## A303 Sparkford to Ilchester Dualling Scheme TR010036

### 8.11 Draft Statement of Common Ground with the Church Commissioners for England

### **STATEMENT OF COMMON GROUND**

<b>Version</b>	<b>Date</b>	<b>Status of Version</b>
Rev A	January 2019	Draft for Deadline 2

Drawing Title
OUTLINE DRAINAGE WORKS PLANS
REGULATION 5(2)(p)
SHEET 1 OF 4

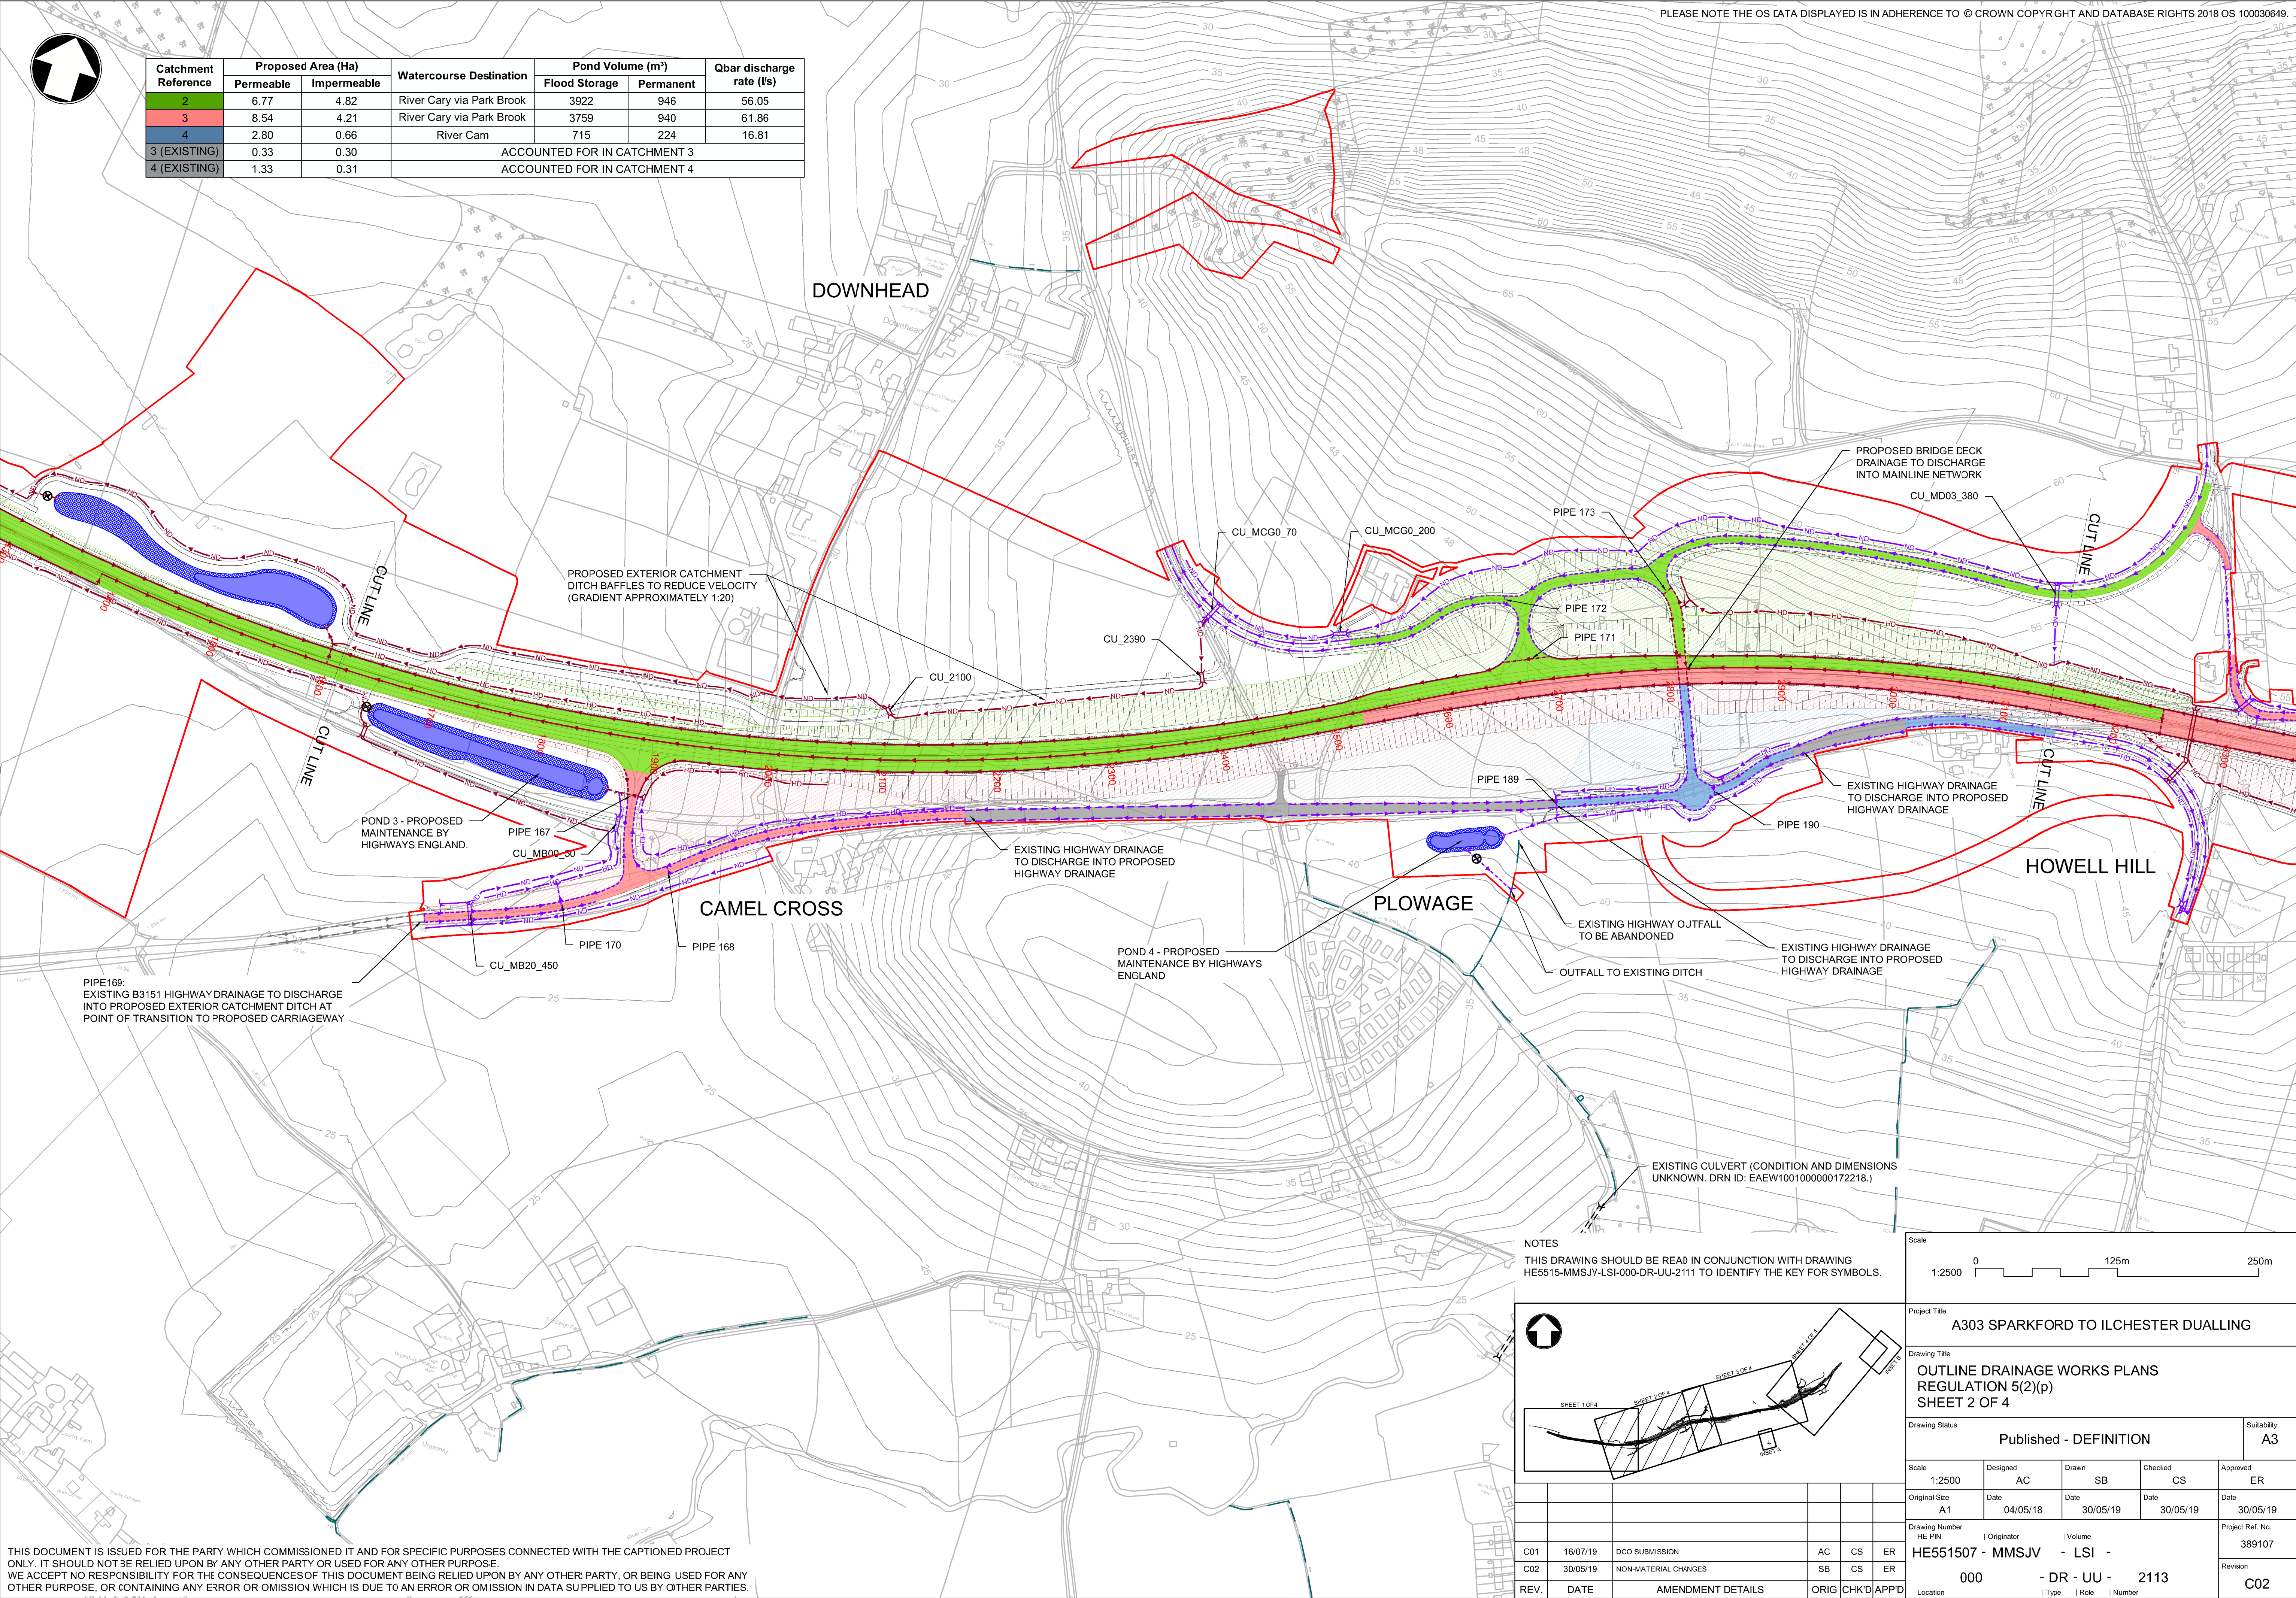
Topic	The Church Commissioners for England comment	Highways England response	Status
Drainage	<p><u>Land at Higher Farm (Title Numbers, WS46264, WS46259, WS46247)</u></p> <p>Our client is concerned by the suggested outfall from pond 1 (Plot reference 1/4a), which appears to lead to their land under title number WS46264. From our review of the proposed drawings, this could lead to 3.47 hectares of the Highway area draining onto our client's land, which already low lying and suffering from poor drainage. This is significantly more than at present. We would contest that this is not a suitable place for such an outfall and it would be advisable to move the outfall to allow water to flow significantly further west along the highway in the direction of the Podimore roundabout. This could potentially connect to the existing culvert at the Higher Farm Lane overbridge, instead of the culvert running across my clients' land. The proposals by Highways England do not appear to show any works to the existing watercourse (ditch) which this outfall will flow into, to ensure it is of a suitable capacity. The proposals as they stand will have an adverse impact on our clients' land. Our client disagrees with the provision of drainage for the scheme.</p>	<p>The drainage strategy, including outfall locations and control measures for flood risk and pollution, is contained within the Drainage Strategy Report (APP-060).</p> <p>Draft Development Consent Order (dDCO) Requirement 13(2)(b)(i) includes a requirement to undertake surveys of the ditch downstream of the proposed drainage outfalls up to the Higher Farm Lane Bridge.</p> <p>Draft DCO Requirement 13(6) includes a requirement that the runoff from drainage outfalls should not exceed the undeveloped rate of runoff. The proposed ponds are intended to ensure that runoff from the road is attenuated to this rate prior to outfall to the local watercourses.</p> <p>Outfall works are included in Plot 1/4a. The works will be designed in detail by the main contractor and submitted for approval by the Secretary of State under Requirement 12 of the dDCO.</p> <p>The dDCO is included in the examination library on the Planning Inspectorate's website as document reference APP-017. The Drainage Strategy Report is included as document APP-060.</p>	<b>UNDER DISCUSSION</b>

Figure 2.2 Main site compound.

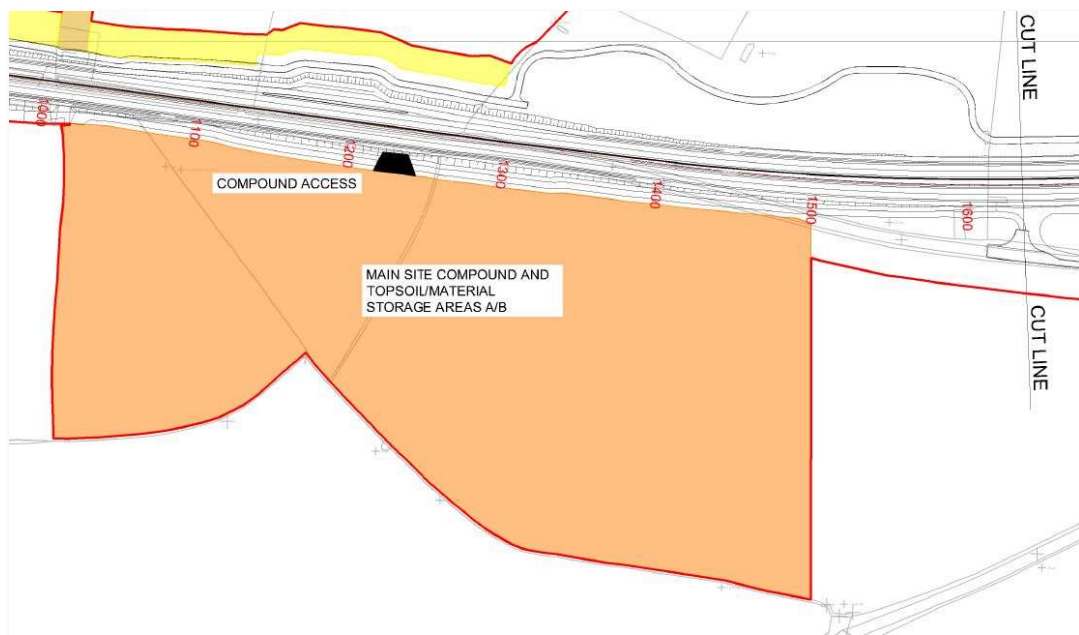
Topic	The Church Commissioners for England comment	Highways England response	Status
Land acquisition	<p><u>Land at Courtry &amp; Speckington Farm (South of A303). (Title Number WS46097)</u></p> <p>The land parcel also includes a works and material storage compound under parcel 2/5b. This area is at least 4.8 hectares and seems rather excessive for the proposed use. The allocated area almost appears somewhat arbitrator. Our client would request justification to show why such a large area is required by the scheme for the purpose outlined. Our client would also request detail of proposed ground protection measures and detail of what temporary drainage provision will be provided on the site to protect our clients neighbouring land from run off. The land is low lying with a heavy soil. During winter months, ground conditions can be extremely challenging. My client would therefore questions whether this parcel of land is indeed suitable for a site compound. If the land is utilised, my client and their tenant farmer will require access to the retained land to the west through the works site. Our client disagrees that the amount of temporary land take is reasonable in this location.</p>	Highways England have commissioned buildability advice from its contracting supply chain. Its advisors have identified this plot as the most appropriate location and size for the main construction compound.	<b><i>UNDER DISCUSSION</i></b>
